STATE OF NORTH CAROLINA
DEPARTMENT OF TRANSPORTATION

Addendum No. 1

RE: Contract ID C202823

Bridges #1 and #2 Over Knobb's Creek On US-17/158

FOR STRUCTURE PLANS, SEE SHEETS S-1 THRU S-125

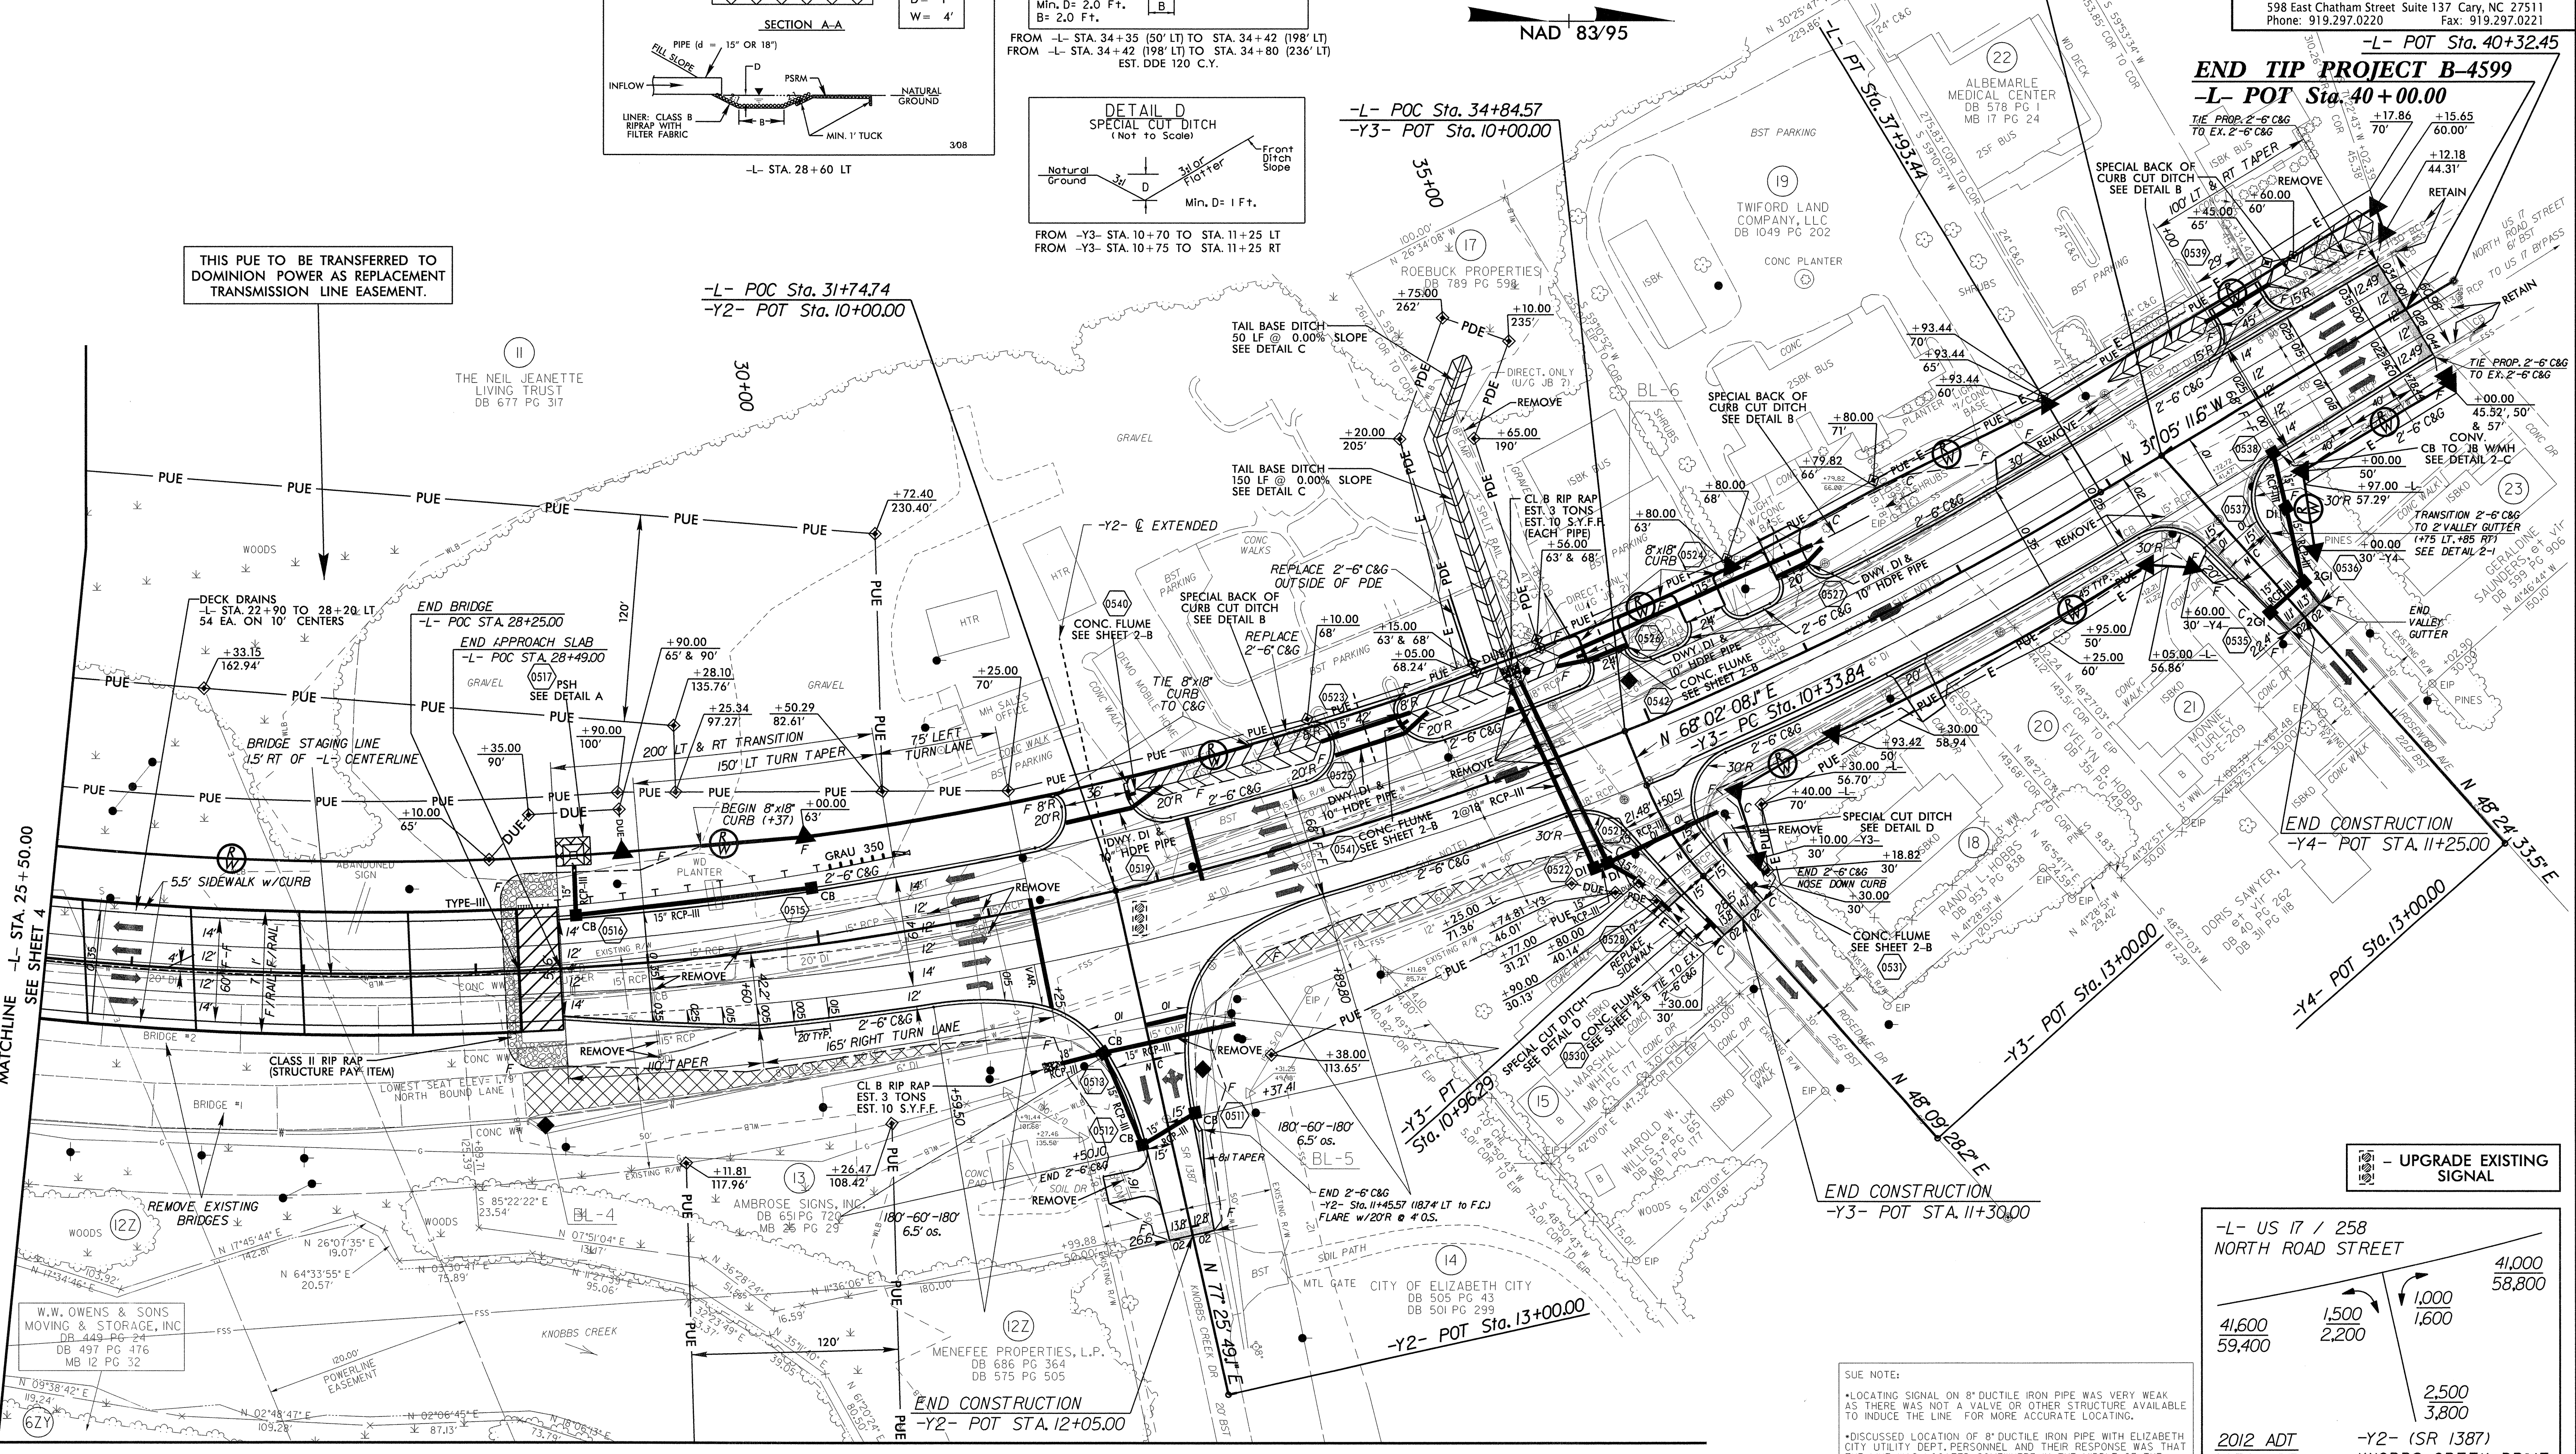
On Sheet Nos. 2, 3-A, 5, 7 and 8 a note has been added concerning "Aggregate Subgrade". Please void Sheet Nos. 2, 3-A, 5, 7 and 8 in your plans and staple the revised Sheet Nos. 2, 3-A, 5, 7 and 8 thereto.
